****** FIELD CHANGE LETTER ******

PROJECT #: 21-2967.1-A (Lot 29)

LOCATION: Lot 29, Woodbridge South

PLANS REF: The Clayton with 2nd Floor – Low Country Elevation by South Designs
Project #: 21-2967.1-GL (sealed 1-12-24)

S-2.2

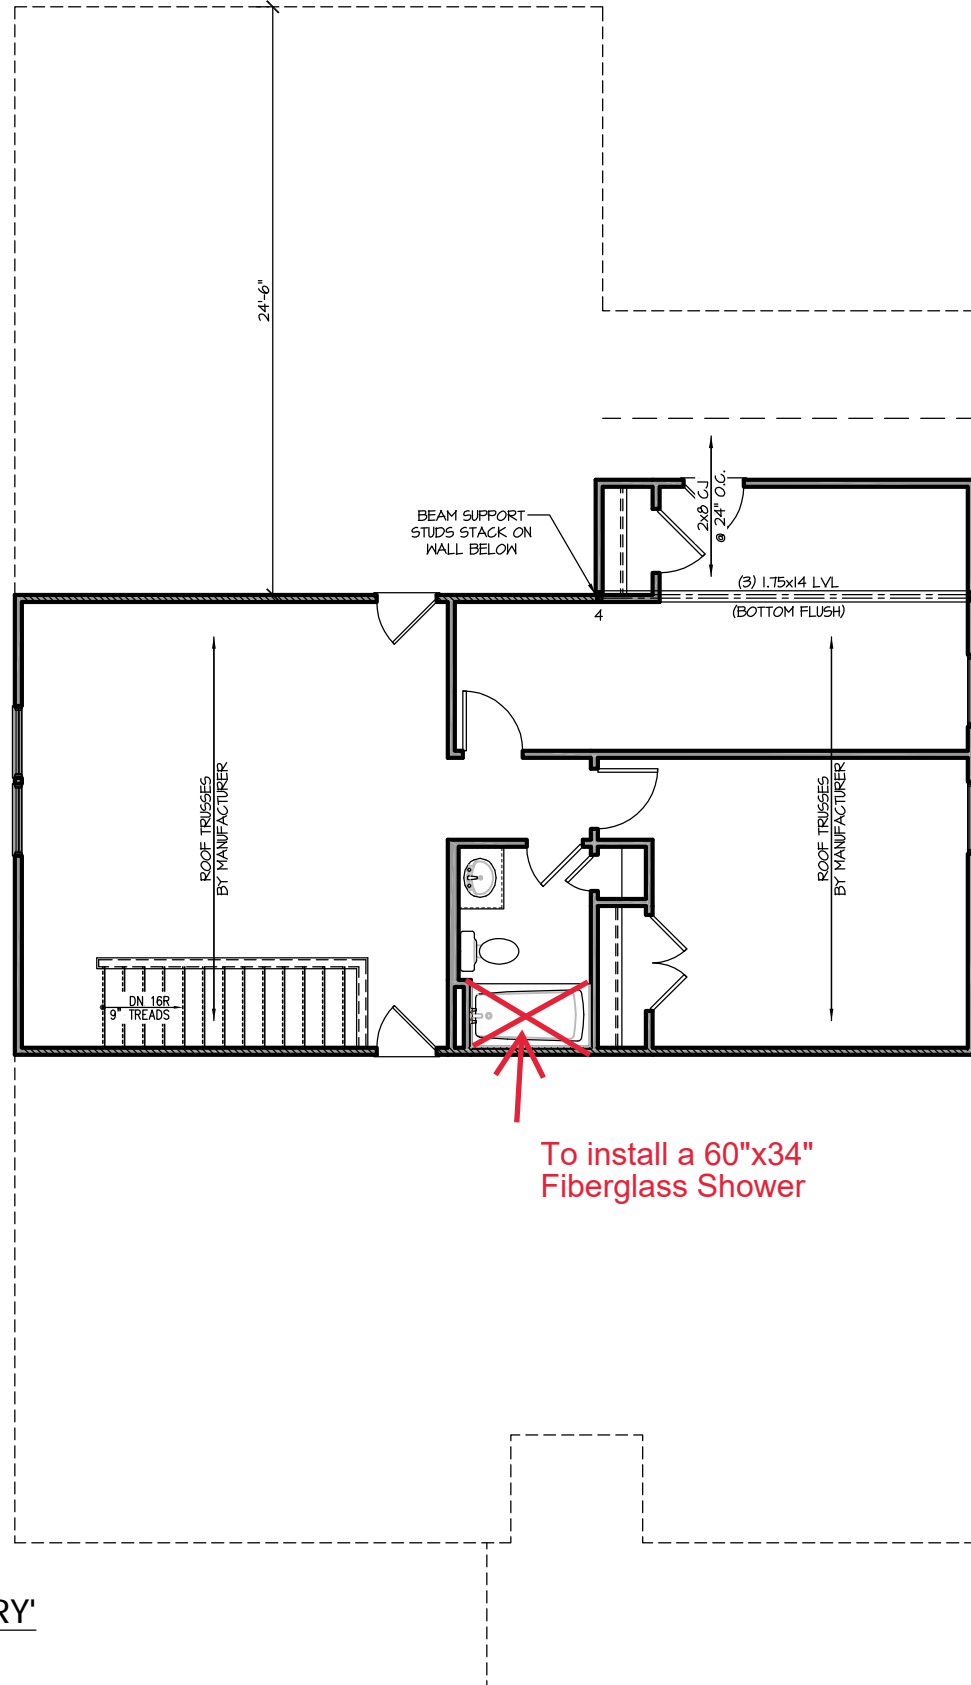
Relocated Truss Support Beam: Sheet S-2.2.2 of the plans shows a (3)1.75x14 LVL spanning left-to-right across the ceiling of bedroom #5. Based on the roof and floor truss placement plans (Job #: J0224-0868 and J0224-0869 dated 2/16/24 by ComTech) the bearing of the roof trusses was not in this location. The front and rear roof trusses were supported by a (3)1.75x18 LVL under the rear wall of bedroom #5. This shifts the loads from the beam approximately 4'-10" to the rear of the original location. The left end of the (3)1.75x18 LVL lines up within the open span of the (3)2x10 girder below and the right end is on the exterior foundation wall.

Response: Please note that the above described relocated truss support beam will be structurally acceptable provided that a 1.75x9.25 LVL is added to the (3)2x10 girder span that now supports the end of the (3)1.75x18 LVL beam. Attach the LVL to the (3)2x10 girder with (2) rows of Simpson SDW22634 screws at 16" O.C. At the foundation wall, fill the bay between joists below the end of the beam with a piece of 1.75x11.875 LVL against the rimboard to provide adequate bearing.
